Appeal Decision

Appeal Ref: APP/Z4718/Z/20/3260754

Adjacent to Castlegate, Huddersfield

- The appeal is made under Regulation 17 of the Town and Country Planning (Control of Advertisements) (England) Regulations 2007 against a refusal to grant express consent.
 - The appeal is made by Mr Alex Simpson (Bee Outdoor) against the decision of Kirklees Council.
 - The application Ref 2020/64/91748/W, dated 11 June 2020, was refused by notice dated 10 September 2020.
 - The advertisement proposed is described as an advertising screen on a single post.
-

Figure No: Figure 9

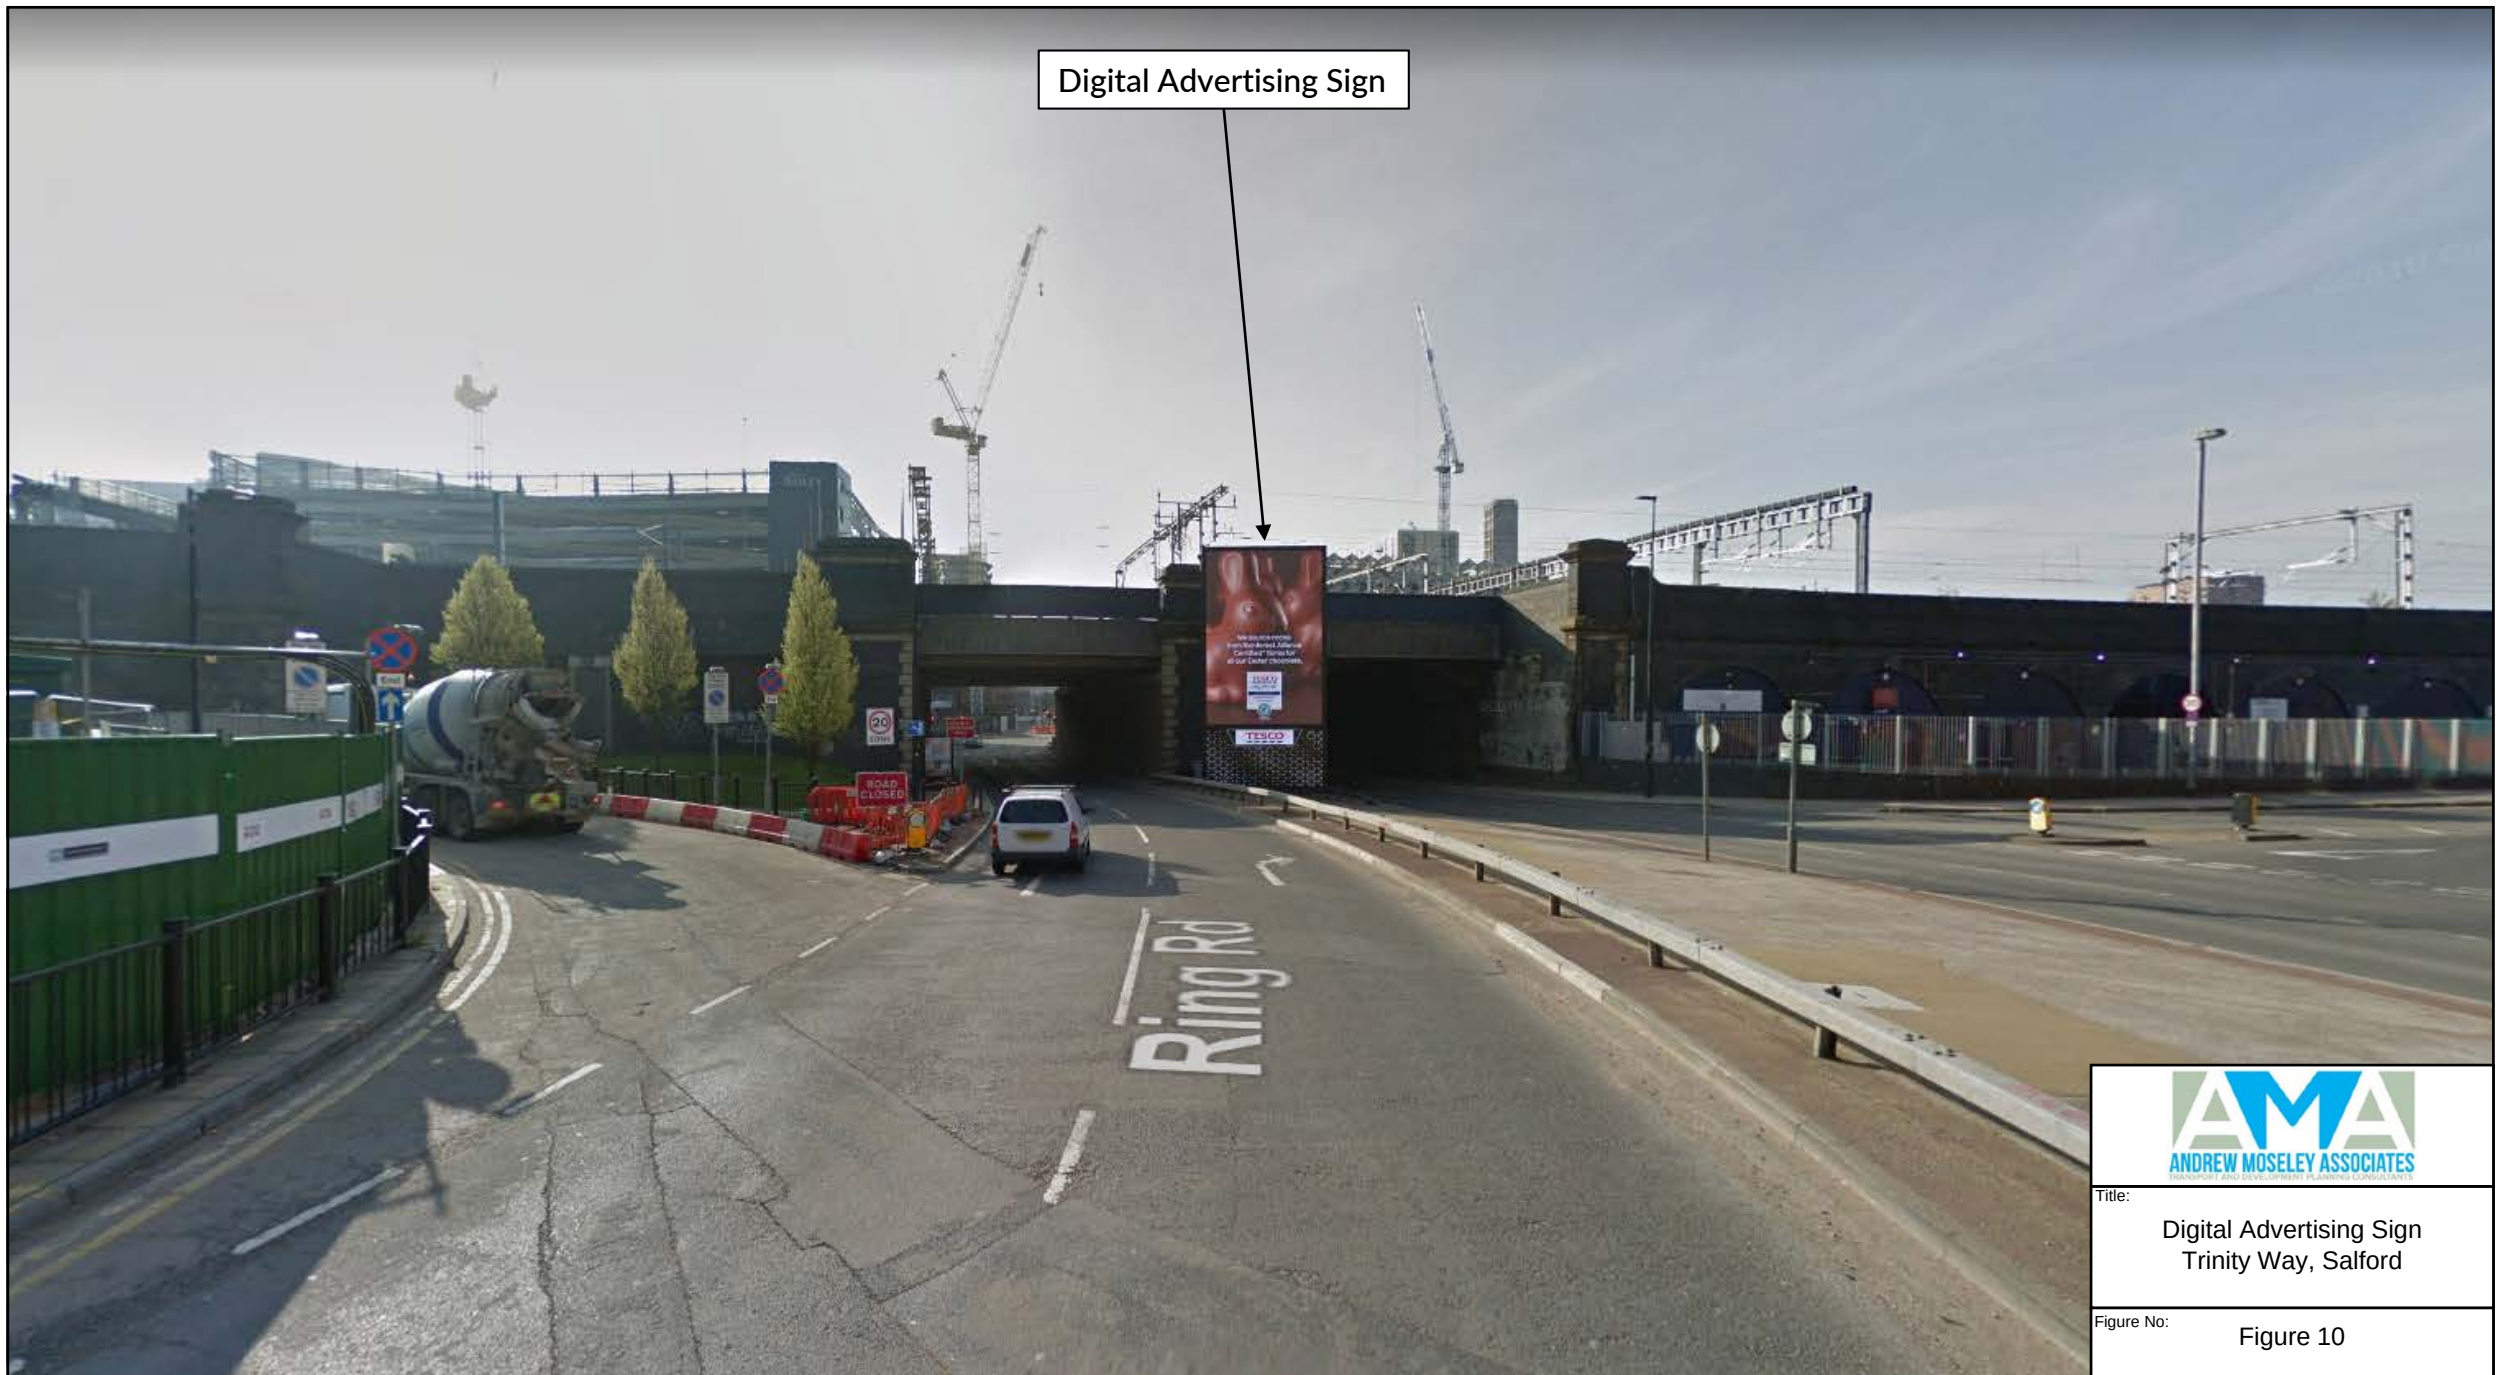
17. The pictures showing the DASs close to the Shorehead roundabout at the A62 in Huddersfield, close to the A61 Hunslet Road in Leeds and close to the A57 in Salford do appear to show signalised pedestrian crossings in varying degrees of proximity (see Figures 8, 9 and 12 of the HSR). This makes them potentially relevant to this appeal. In 2 of the cases (Huddersfield and Leeds) the DAS is of comparable size.

19. The DAS in Leeds sits back from and to the left of the A61 Hunslet Road and faces approaching drivers, coming increasingly into view as they get closer. It has not resulted in any change in the pattern of crash patterns nor increased the number of collisions.

Proposed elevations

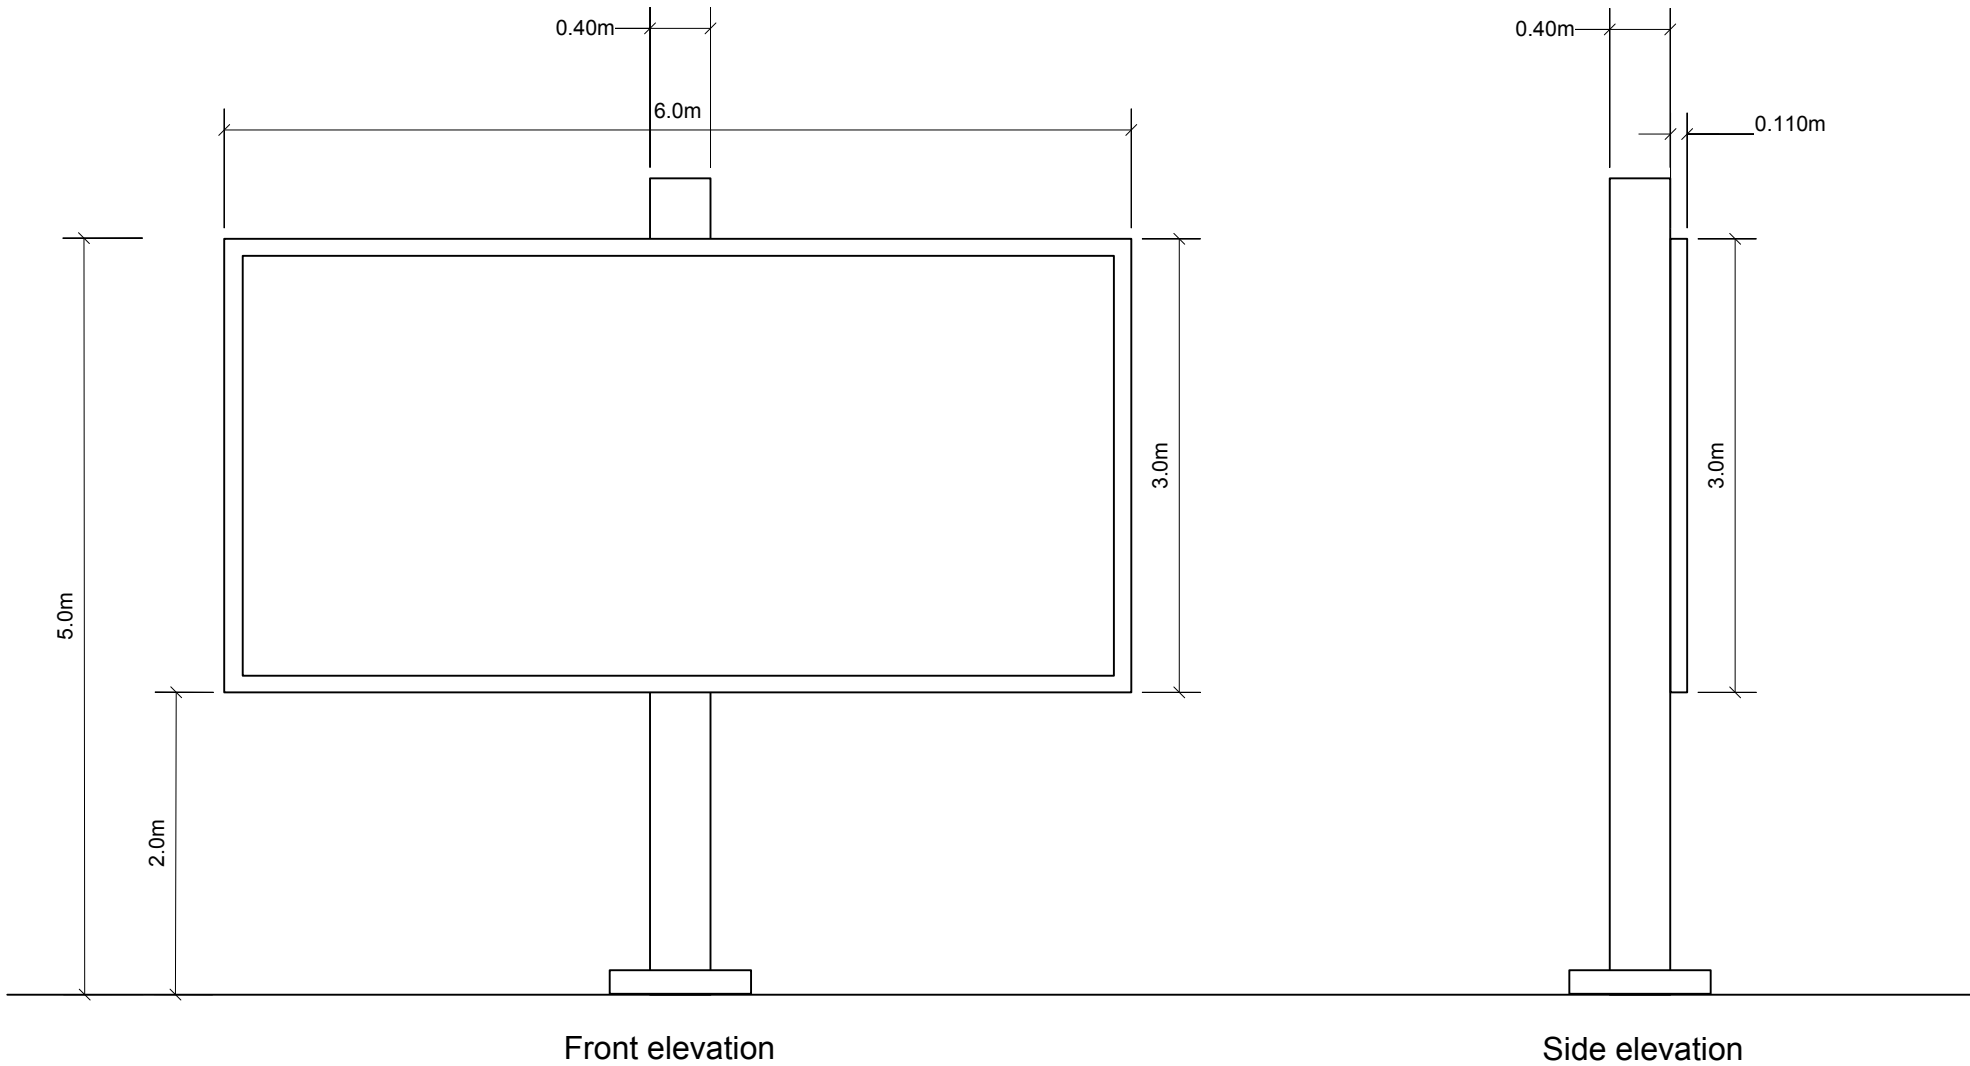
8. The electric backlit LED DAS would be around 6 metres in width and 3 metres in height, supported by a 2-metres high central upright. The images would be static and would change instantaneously every 10 seconds without any transition. The DAS would face across the intersection in a broadly north-eastern direction.

11. The proposed DAS would be positioned on the inside of the bend immediately before the pedestrian crossing on the slip road. At this point traffic is likely to be moving at around 25-30mph in both the morning and evening peak hours as it approaches the pedestrian crossing and then, almost immediately after, a 'Give Way' sign with priority for vehicles crossing from Lower Fitzwilliam Street to Castlegate (see Figures 2 & 3 of the Appellant's Highway Safety Report, November 2019) (HSR). Consequently, vehicles would be driven quite cautiously through this short section of road as evidenced by only one PIC over the past 5 or so years.

12. The approaching drivers would initially see only the blank side elevation of the DAS on the grass verge to the left of the slip road. Because of its proximity to the highway and because of its orientation the driver would first see the advertising image at the point where his / her vehicle was almost immediately in front of the DAS.

13. The surprise element created by the near-adjacent advertising image would mean that there would be a real possibility that the driver's attention would be momentarily distracted from looking ahead. This would be particularly so for those unfamiliar with the local road network.

14. It is also at this point that the driver would be almost on top of the pedestrian crossing. Even though vehicles would be moving quite slowly through this section the presence of a DAS would unacceptably increase the risk of an accident.
